As per Section 7 of the Department of Planning & Environment's Response to Submissions (attachment B), Mirvac has provided documentation that encapsulates the recommendations and responses for Project '3.1 – Site 53'. Refer to the Design Review Panel (DRP) Advice Sheet. This document summarises the contents of the DRP Advice Sheets.

SOPA Design Review Panel 19.03.15

SHADOW STUDY

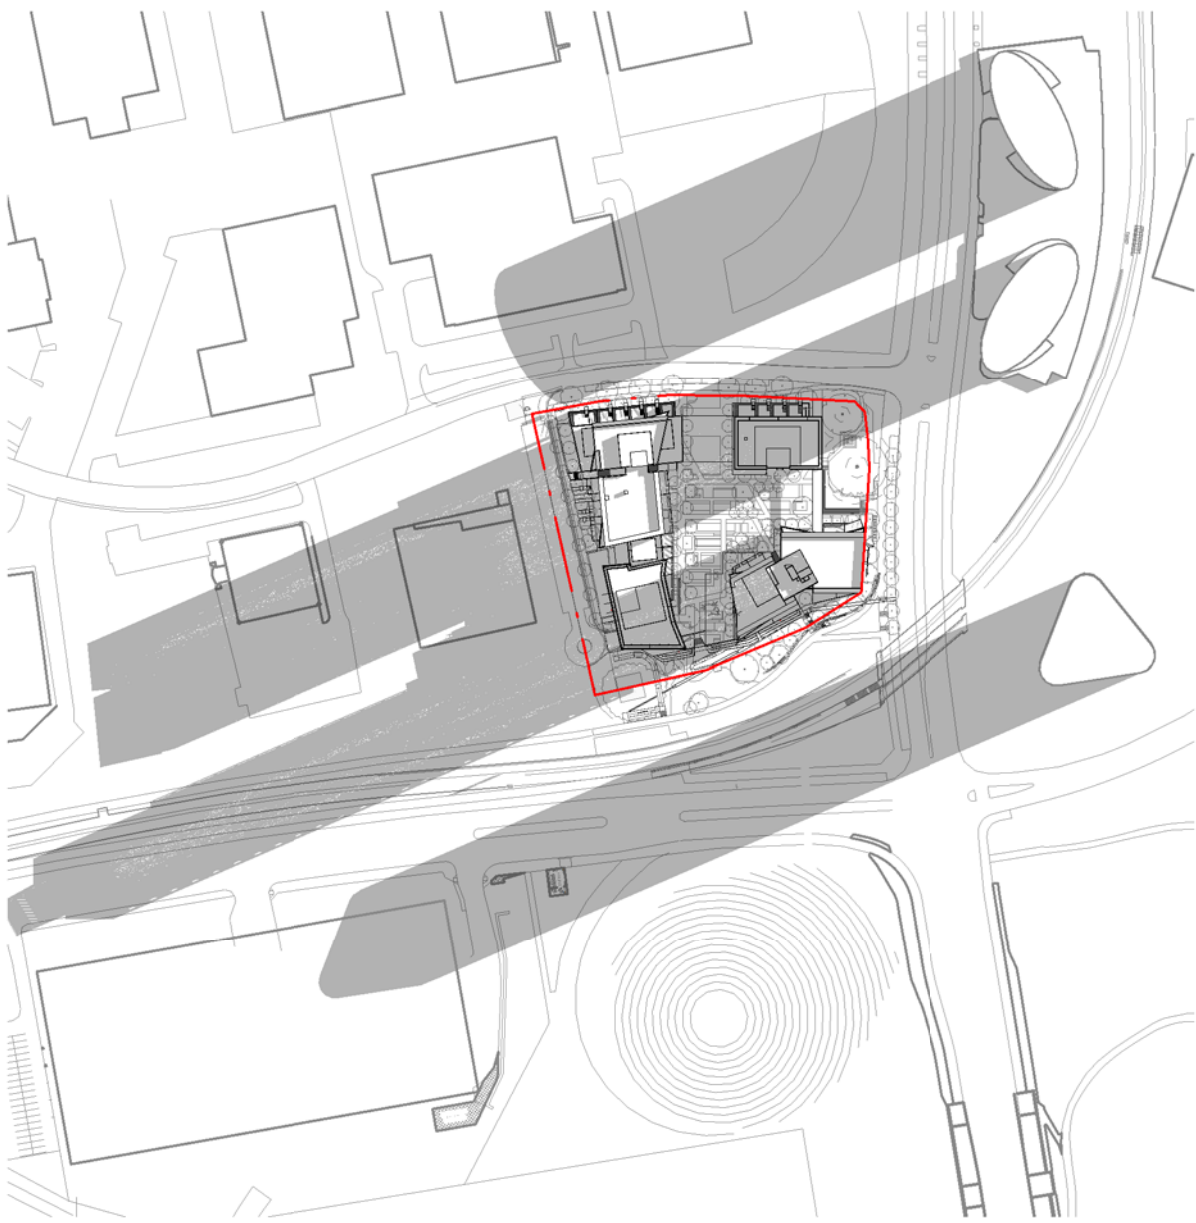
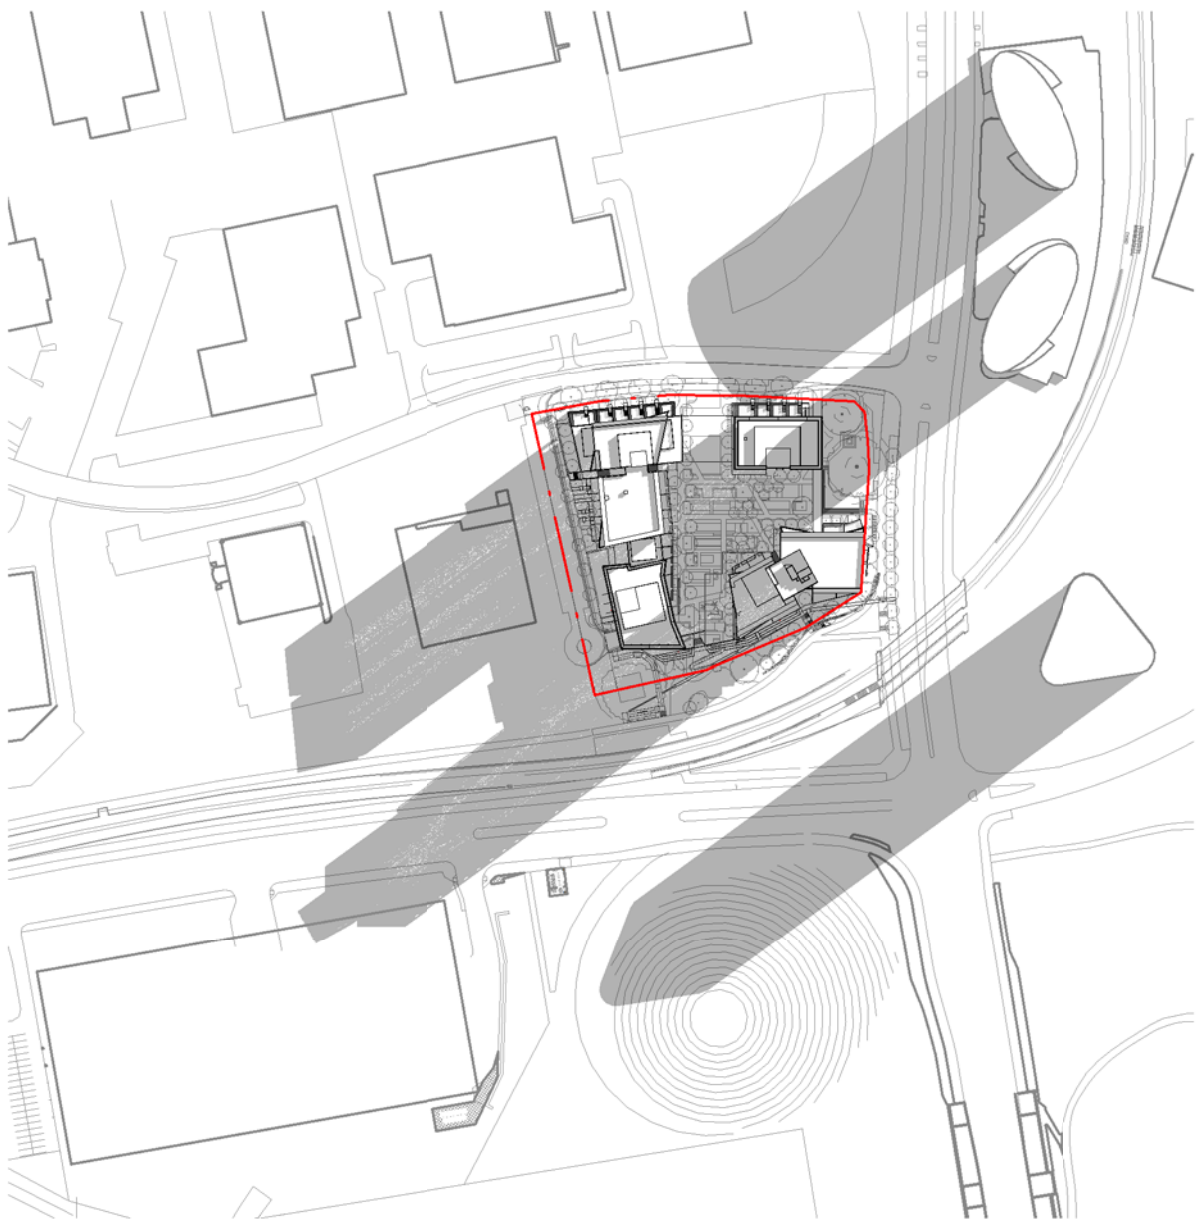
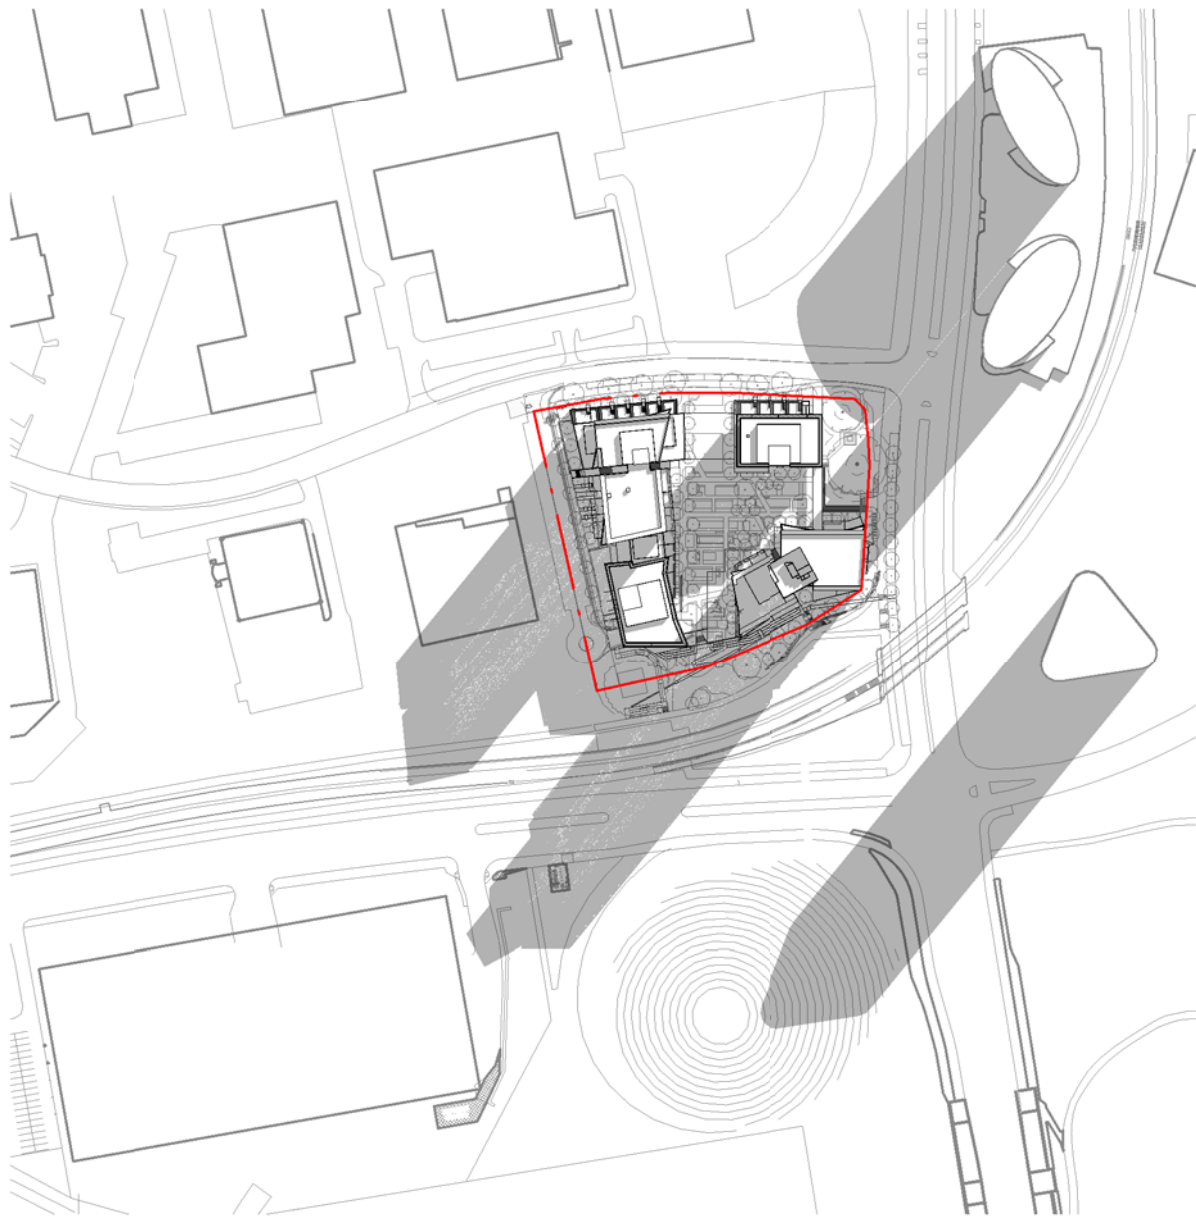
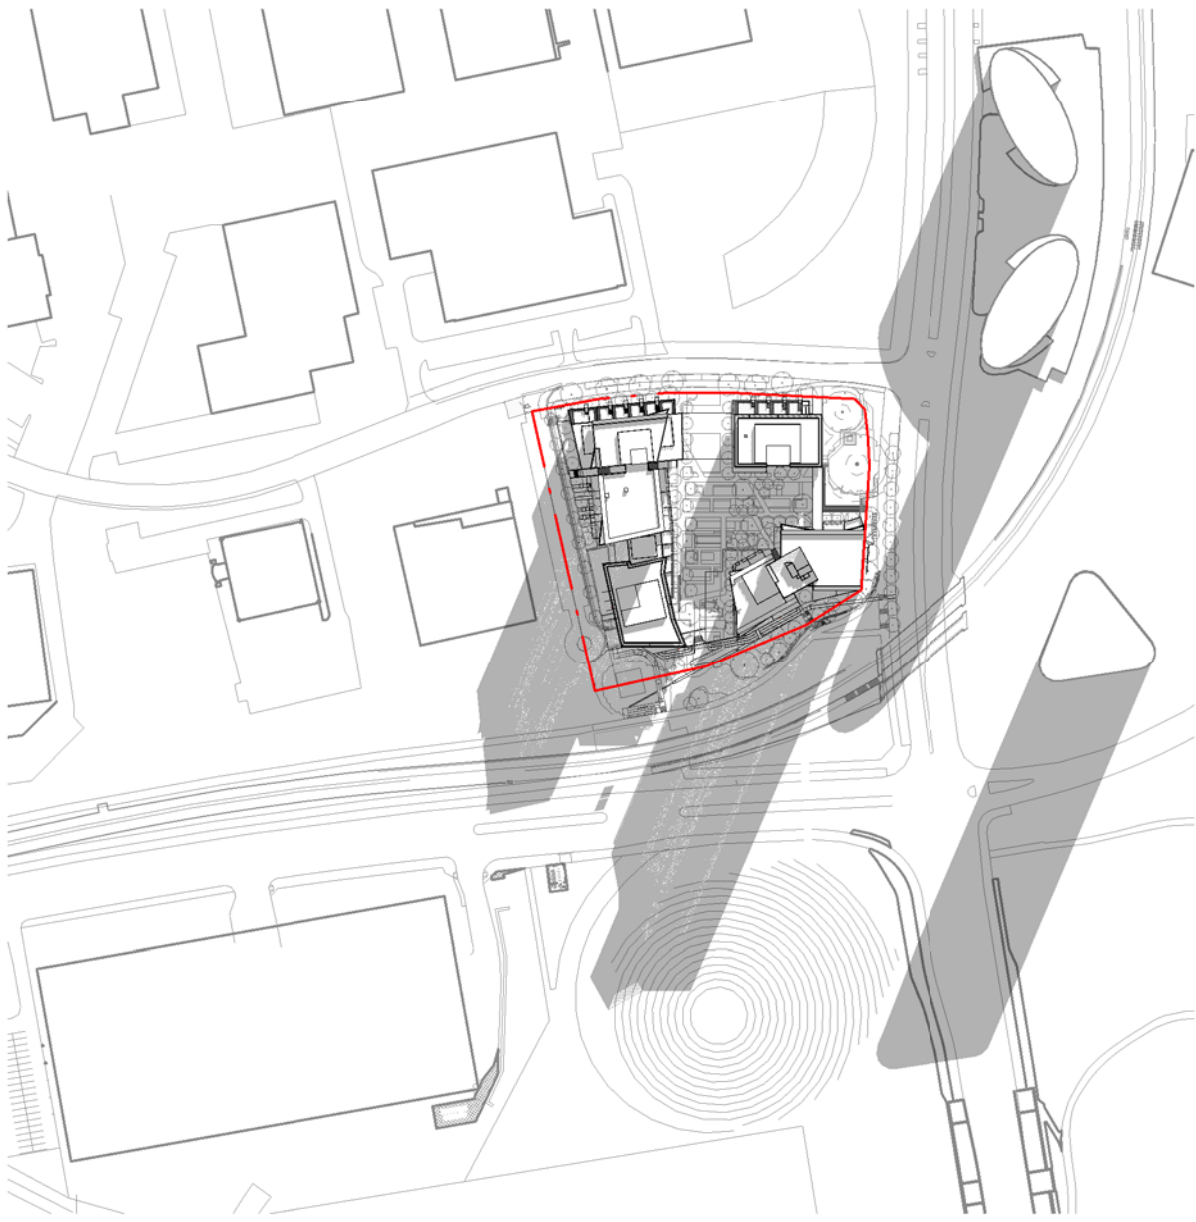
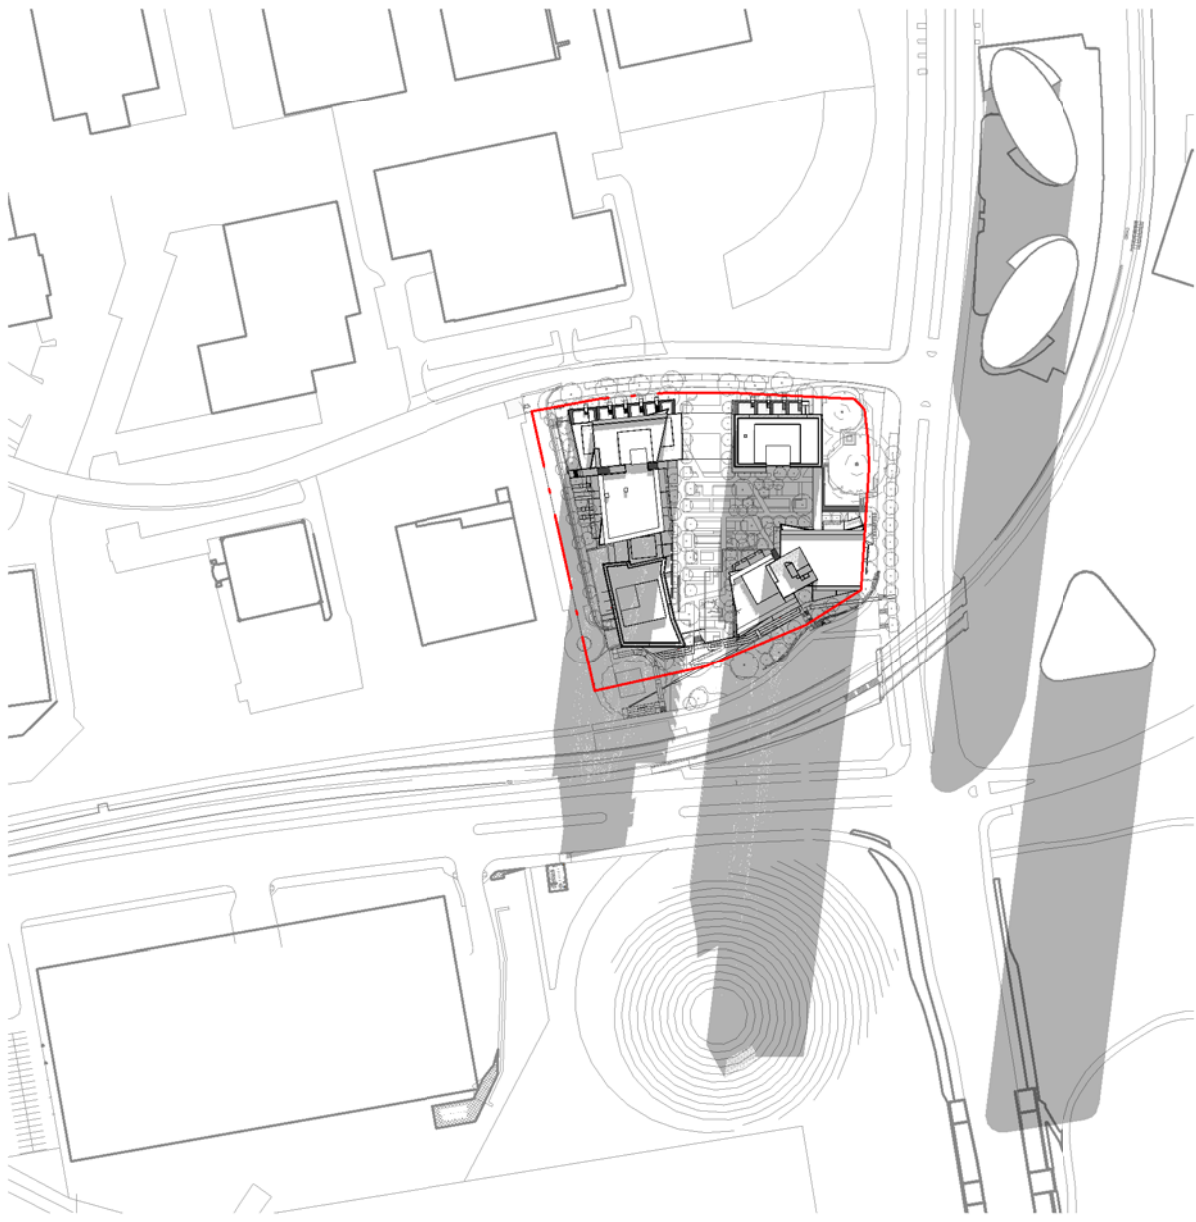
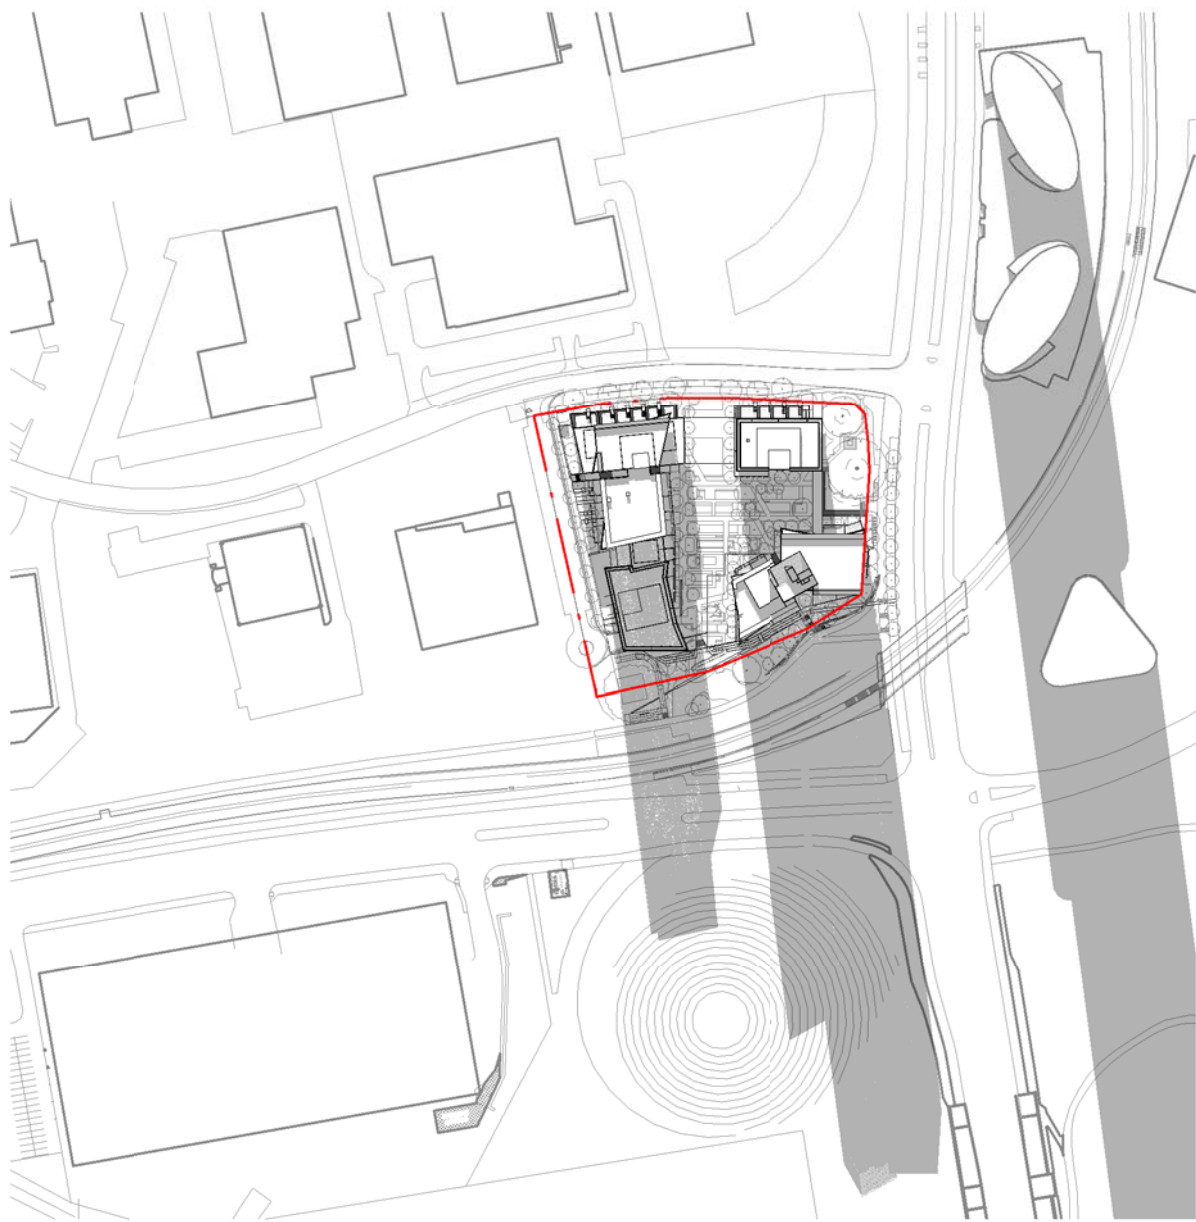
- Large number of units access from each lift will discourage community interaction
- The percentage of units achieving 2 hours sunshine on June 21 has decreased
